**Re: Objection to MP08 0244 MOD 1 -
Modification Request for Mixed Used Development at 23-37 Lindfield Avenue
and 11 Havilah Lane, Lindfield**

1 KOCHIA LA ELEVATION
SCALE 1 : 250

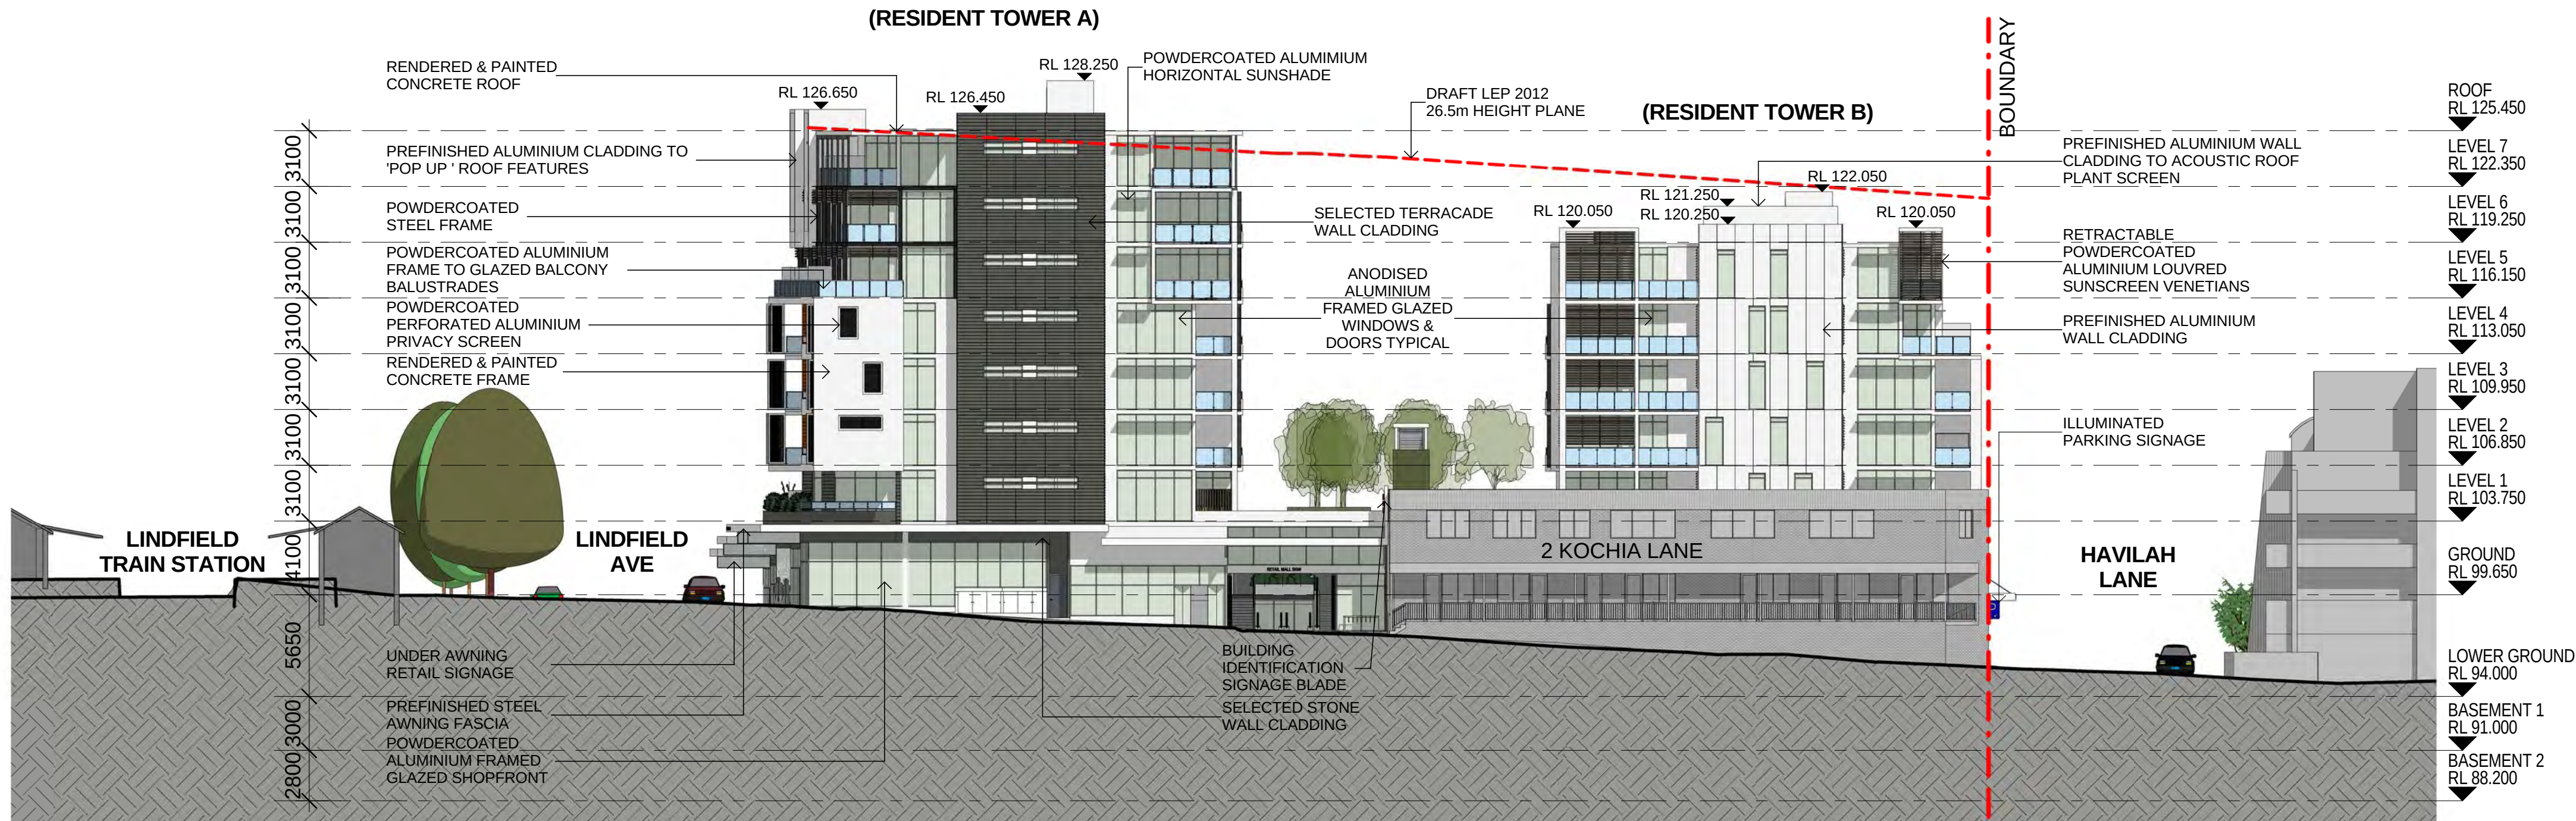
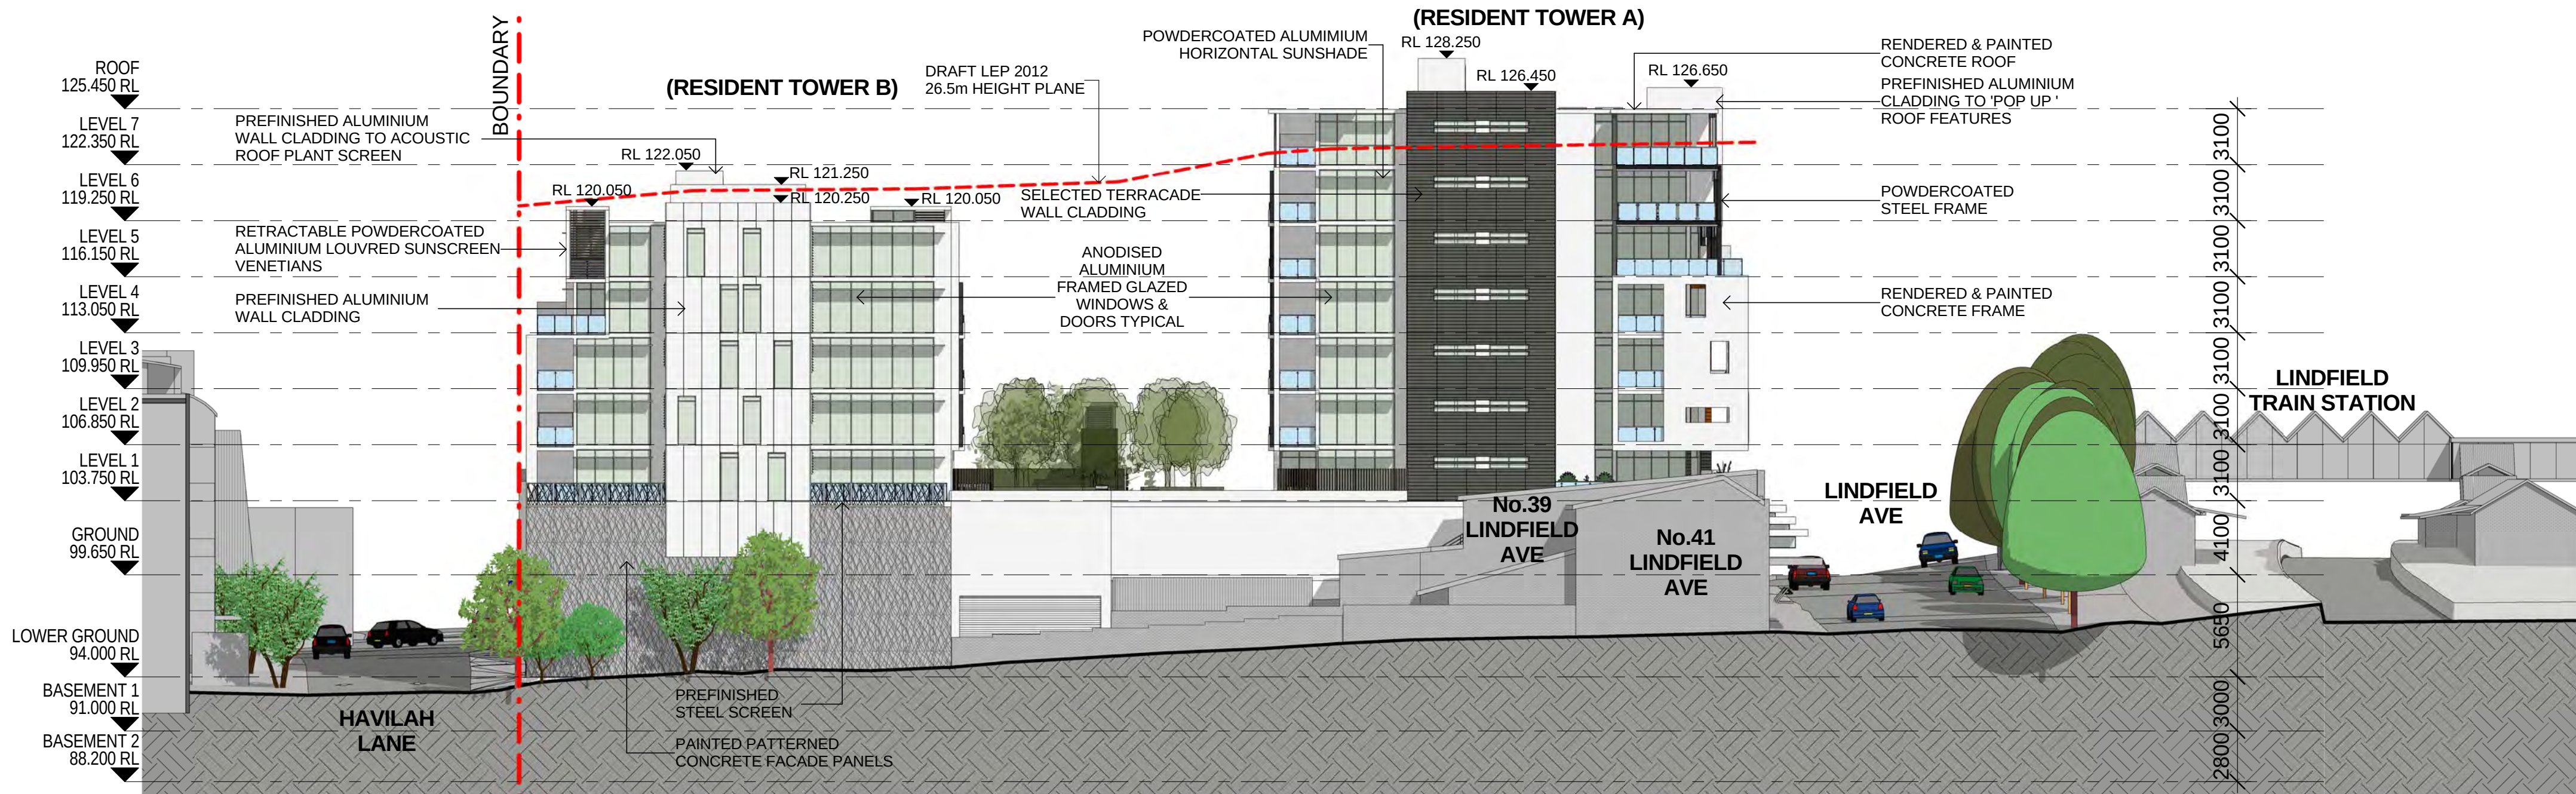
The proposal in this Modification is completely **incompatible and inconsistent with other recent developments** around Lindfield station. The increase of an additional storey to both buildings – to 8 storeys on Lindfield Avenue and to 7 storeys on Havilah Lane under this Modification – would create excessive height and bulk and is **totally out-of character with the surrounding buildings**, including the **heritage-listed adjacent building** on Lindfield Avenue.

5. The additional storey (combined with less set-back than was in the originally approved design) on Havilah Lane now creates privacy concerns for over 40 apartments in the adjacent 8 Havilah Lane, 8 Kochia Lane and 2-8 Milray Street residences. This will adversely impact on the amenity of the residents of these apartments in their homes and outdoor spaces.
